Comhairle Contae Chill Mhantáin Wicklow County Council

PRR No: 23/60219

RE: Planning and Development Regulations 2001(as amended) – Planning Register Reference 23/60219 - Keldrum Limited - LARGE SCALE RESIDENTIAL DEVELOPMENT - (a)Construction of 352 no. residential units (b) The proposed development will connect to the Tinakilly Park residential development and Rathnew Village via a new section of the Rathnew Inner Relief Road. The proposed road will join the constructed/under construction elements permitted under WCC Ref. 17/219/ ABP Ref. PL27.301261 and amended under WCC Ref. 22/837 to the south with a section of the link road to the northwest of the site at the R761 roundabout in Rathnew granted under WCC Ref. 21/1333. This includes all associated vehicular and pedestrian access, carriageways, paths and junctions. (c) No proposed works to Tinakilly Country House Hotel (a protected structure Reference No. 25-15) save for works to close the western portion of Tinakilly avenue to vehicular traffic and the provision of a new vehicular entrance and gates along the eastern portion of Tinakilly Avenue off the Rathnew Inner Relief Road to facilitate access to Tinakilly House and other

Client	Keldrum Limited
Project	Large-scale Residential Development at Tinakilly, Wicklow
Title	Hotel Entrance Arrangement
Dwg. No.	A034-CSC-ZZ-XX-DR-C-0045
Date	March 2023
Drn. by	SC
Chkd. by	JF
Apprd. by	OS
Scale	1:200 @ A1
Revision	<b>P2</b>

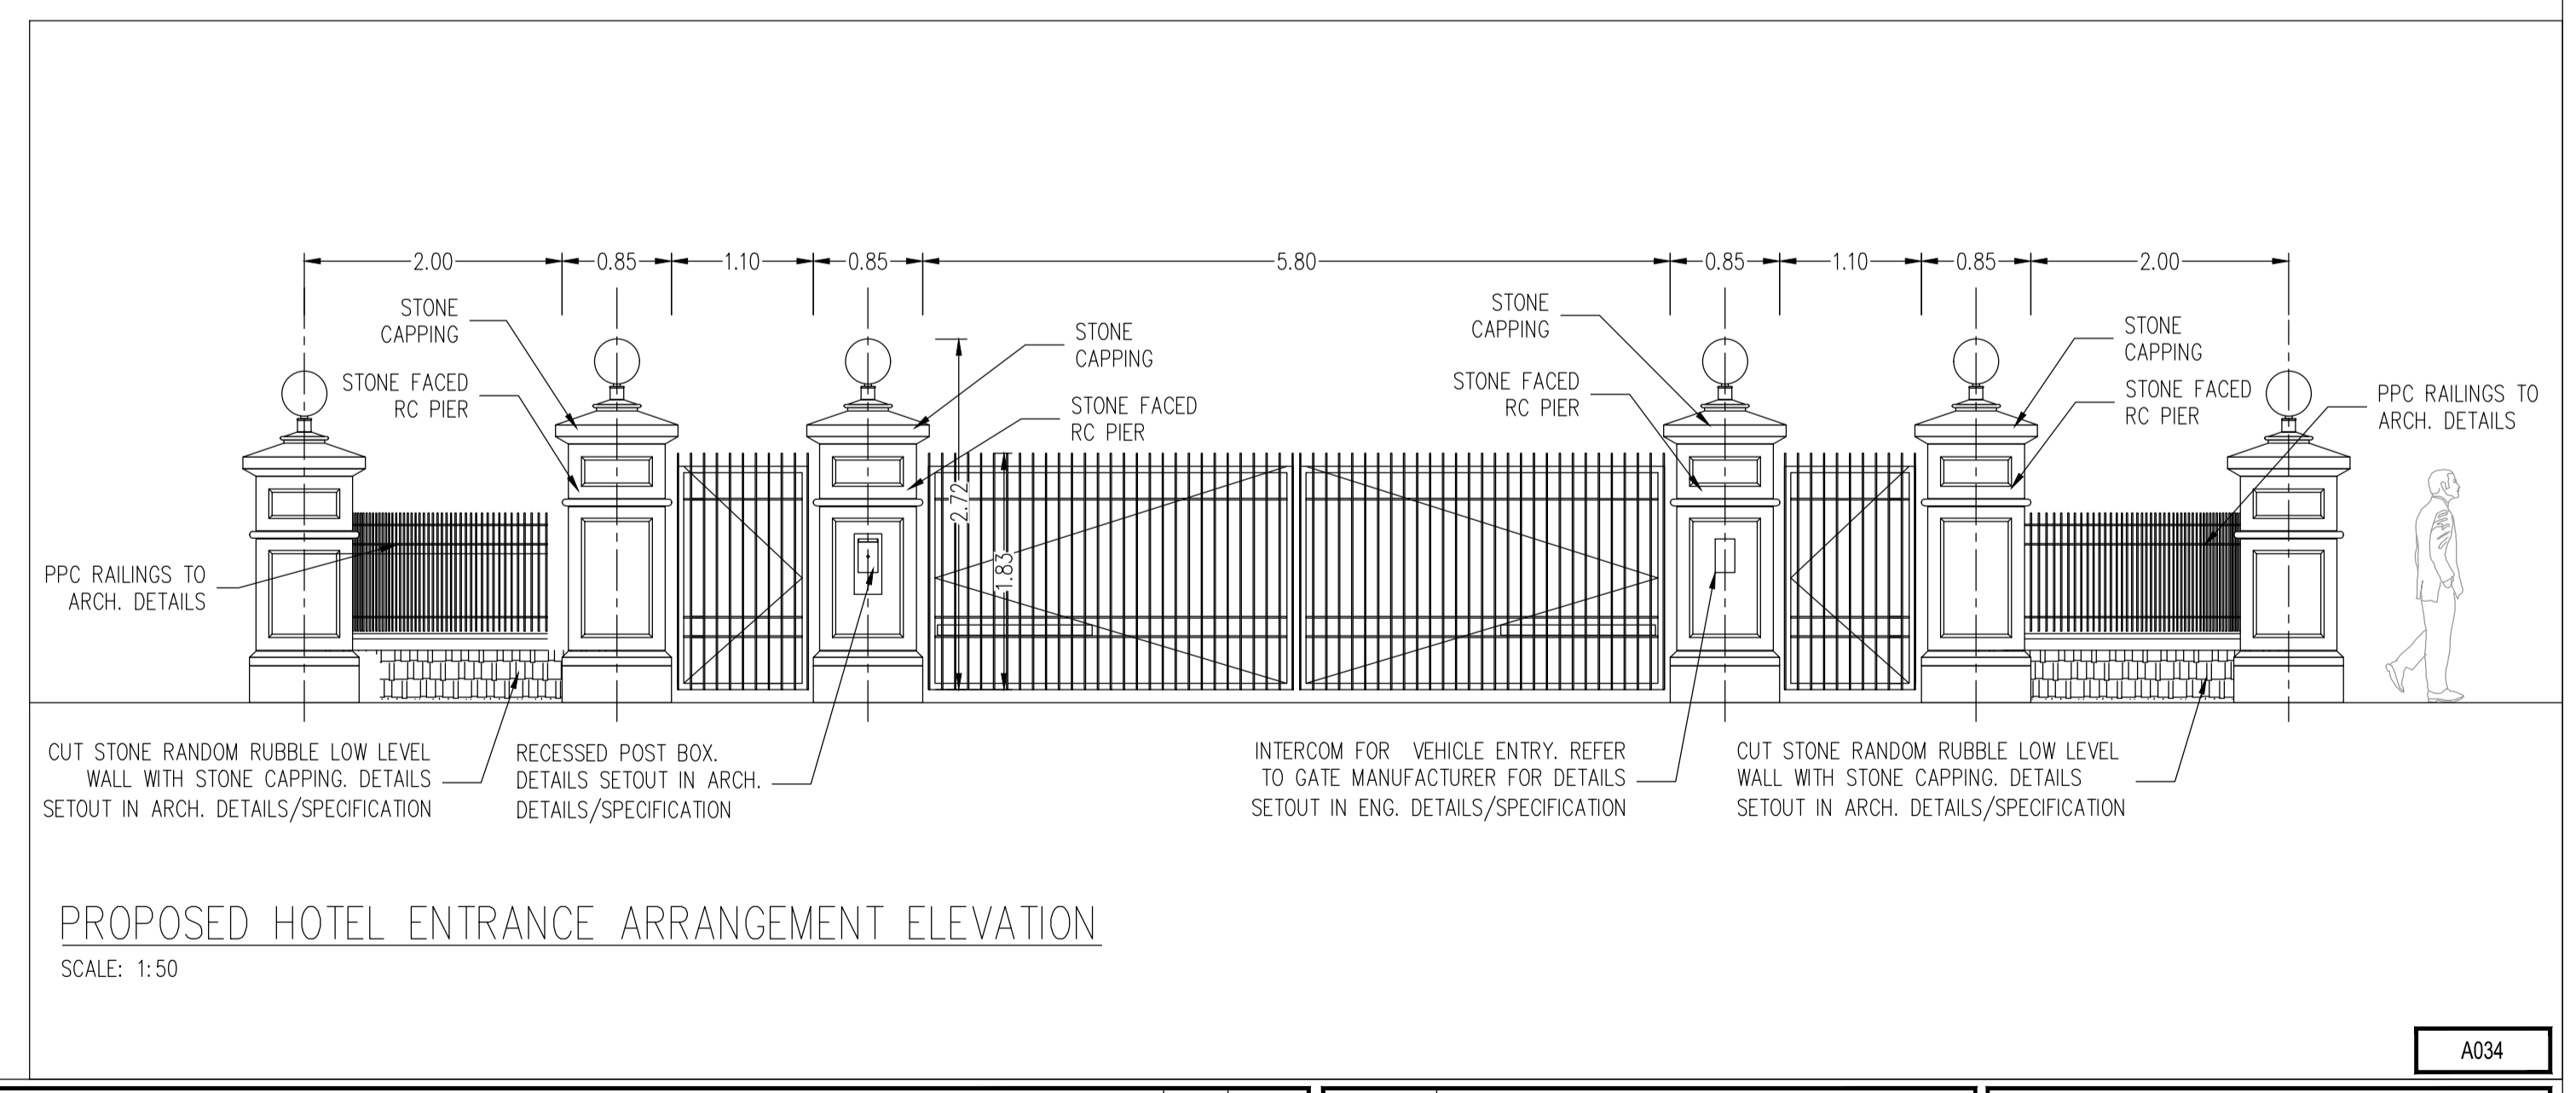
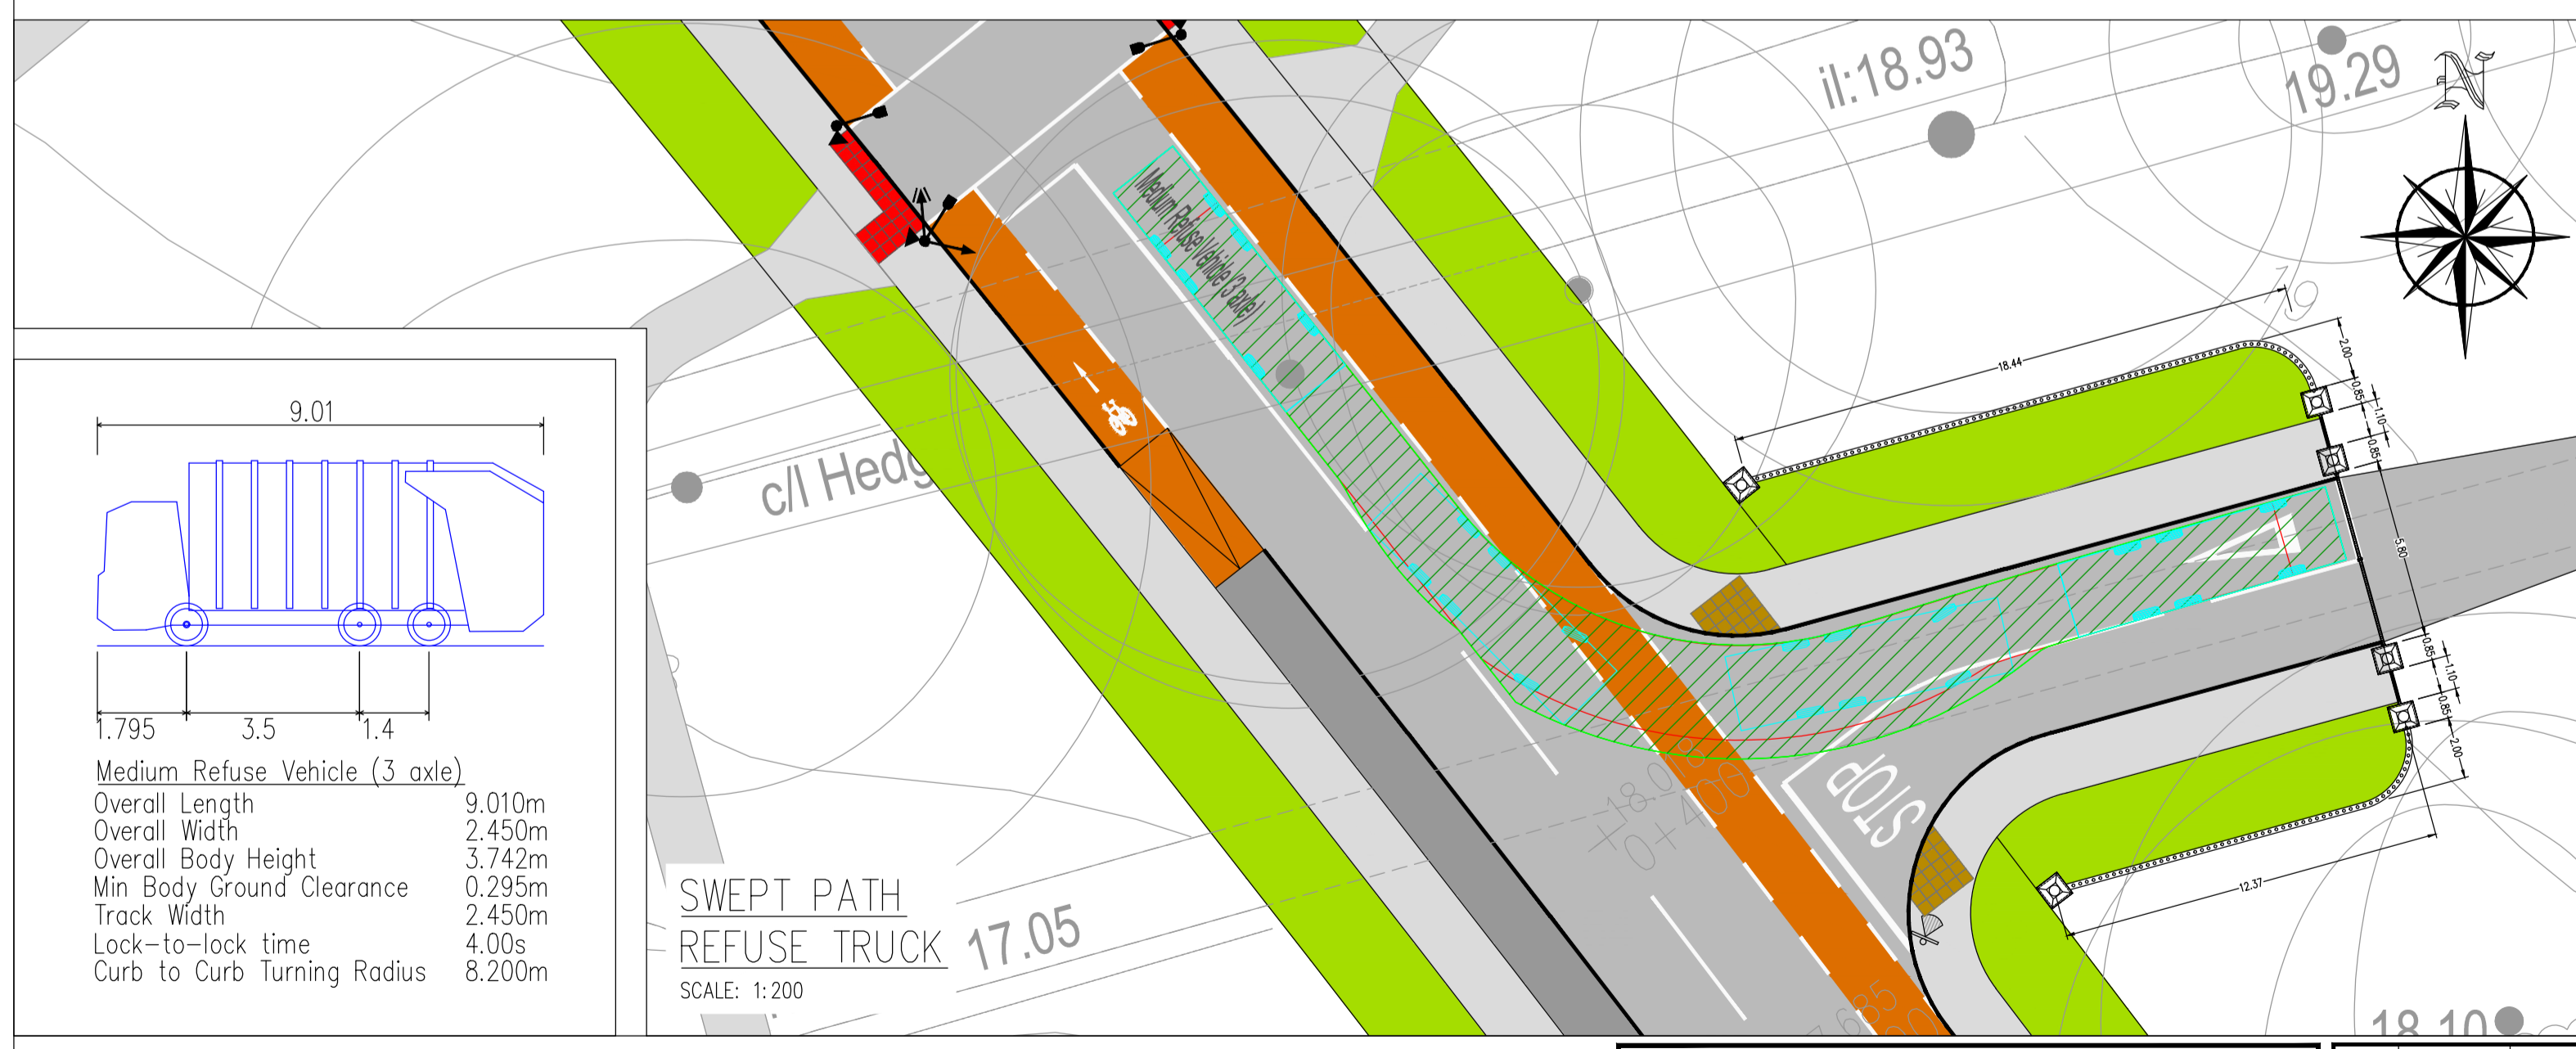
d) The proposed development, by virtue of the proposed controlled gates located on the existing Tinakilly Avenue to the east of the proposed Inner Relief Road, would effectively block vehicular, cycle and pedestrian access to existing dwellings located on the road leading to the Murrough SAC/SPA. No information, or evidence, has been submitted that the Applicant has sufficient interest to carry out the proposed blocking of such access

In responding to this item, the Applicant may wish to submit revised proposals to address any matters identified.
